CITY OF ALBUQUERQUE

Re: Cheddar's

Engineer's Stamp date 1-31-13 (F17/D006)

Based upon the information provided in your submittal received 2-4-13, the above referenced plan cannot be approved for Site Plan for Building Permit action by the DRB until the following comments are addressed:

BERM DETAIL  
NOT TO SCALE

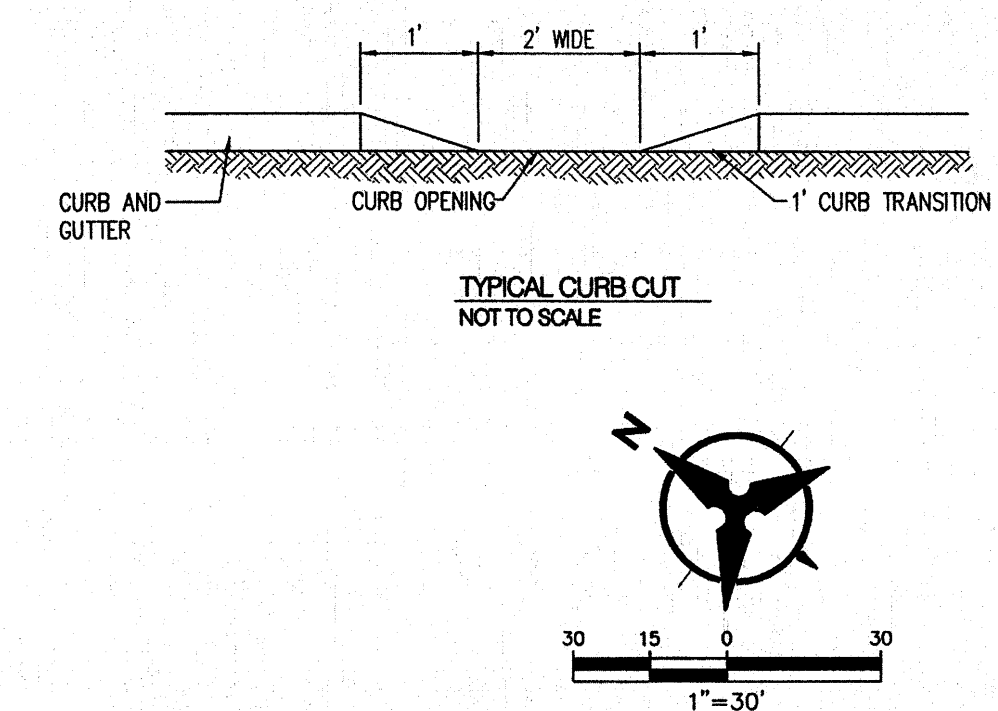
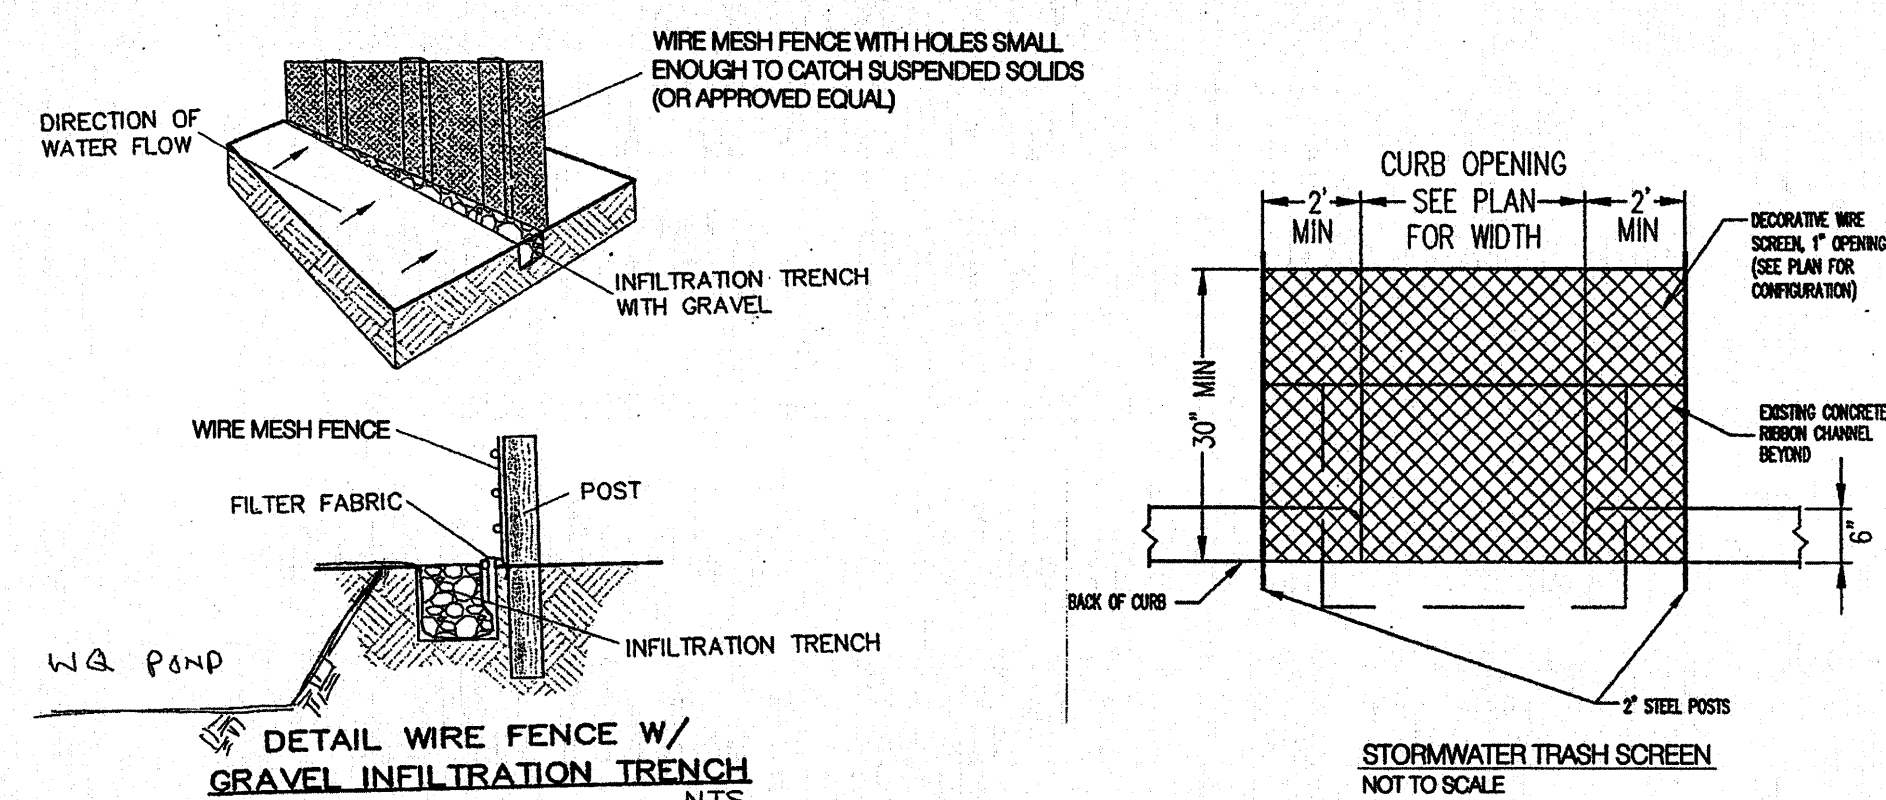
2. Why are you proposing a berm along the frontage road? Depressed landscape areas can function as water harvesting areas to support plant growth.
3. The berm along the southern edge of the site is to be extended east to the edge of the "gravel parking area" as a minimum. The berm has a large tie slope that will drain and deposit sediment onto the PNM site. This height of the berm should be reduced or covered in gravel mulch to prevent erosion.

1. This site should drain to the southwest corner of the paved area, through a rip-rap/hard-lined swale to the inlet located at the southwest corner of the site.
